South East and London Area Team

9 June 2026

Your reference: EN010147
Site: Botley West Solar Farm

Strategic Arboricultural Impact Assessment & Method Statement

**Botley West Solar Farm
 Statutory / Non-Statutory Sites and Features
 of Nature Conservation
 Sheet 12 of 24**

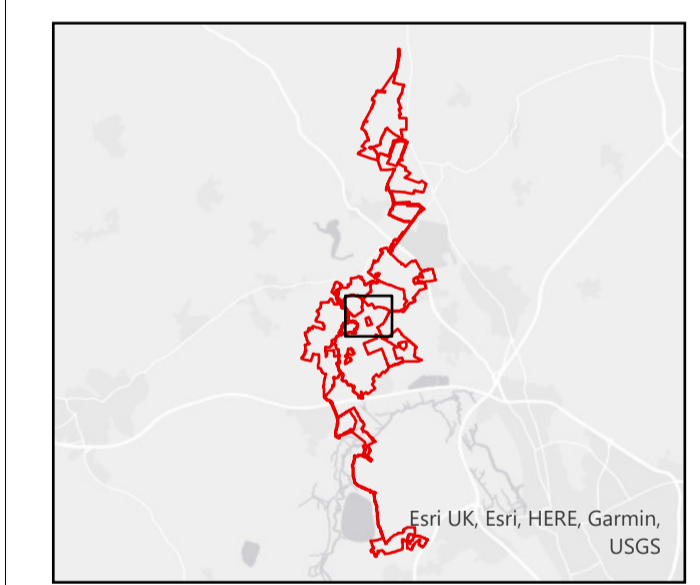
We also welcome the request to the applicant to update the oLEMP to highlight the area between Bladon Heath and Burleigh Wood which will be kept free of panels and be managed to ensure connectivity between the woodlands, along with detail of the management proposed.
